Application No. 2023/91068

We are contacting you following the notice received concerning alterations to 57 Douglas Avenue, Soothill, Batley, WF17 6HQ.

SIDE ELEVATION

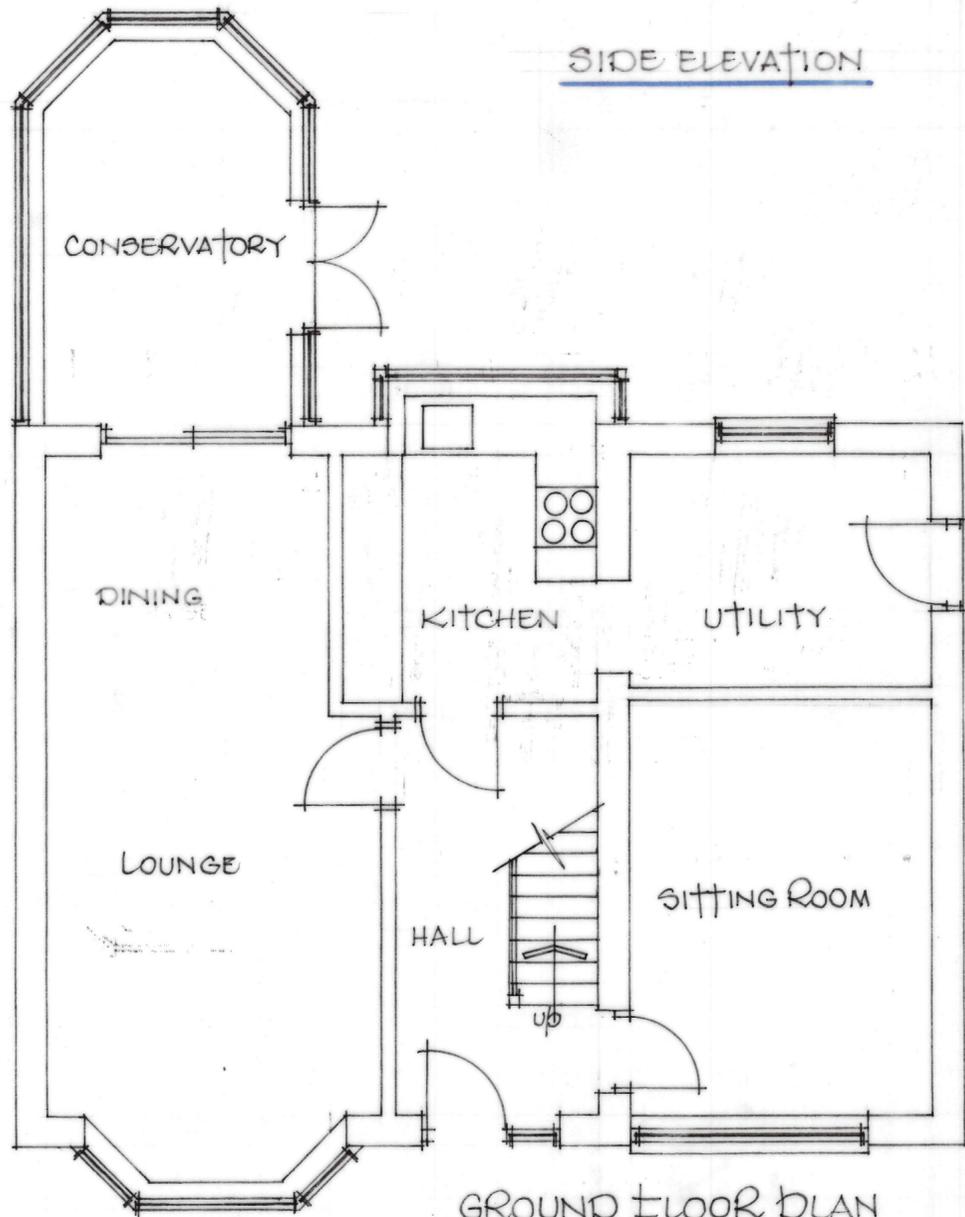
"We are very happy to support this application, alongside other extensions within the surrounding area, however, we very strongly object to 2 of the windows

Window 1, location - gable end

The windows are

we hope a slight planning ammendment to remove the windows  
would be accepted.

FIRST FLOOR PLAN

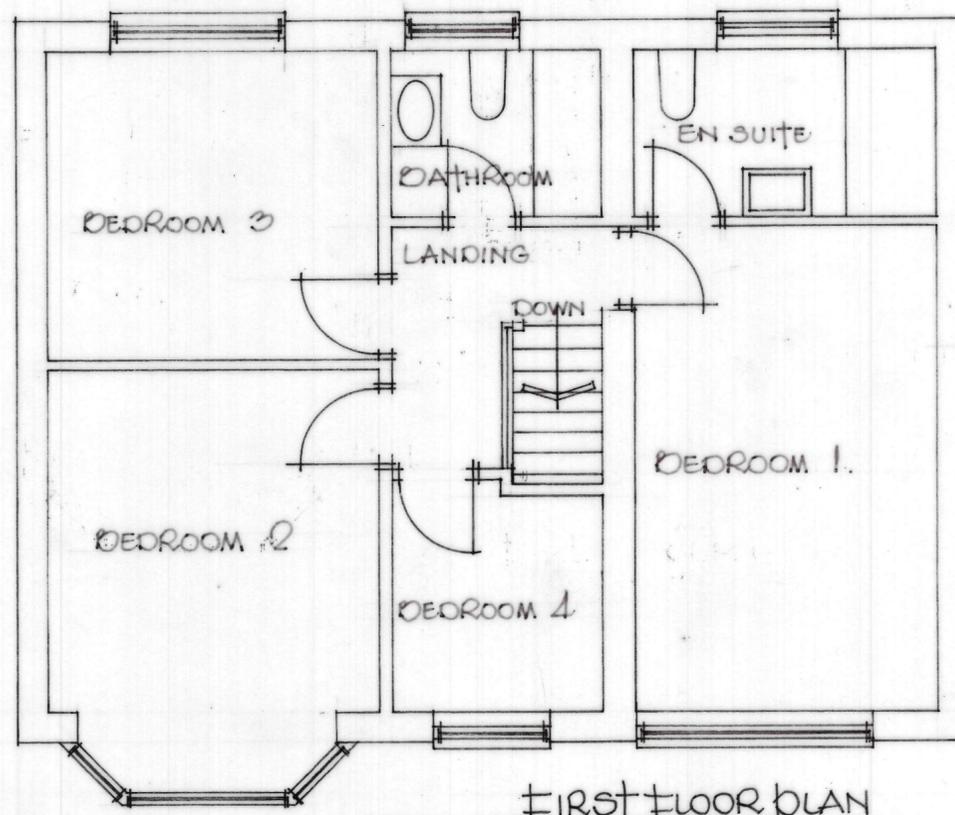
Window 2, location - side of bedroom 3
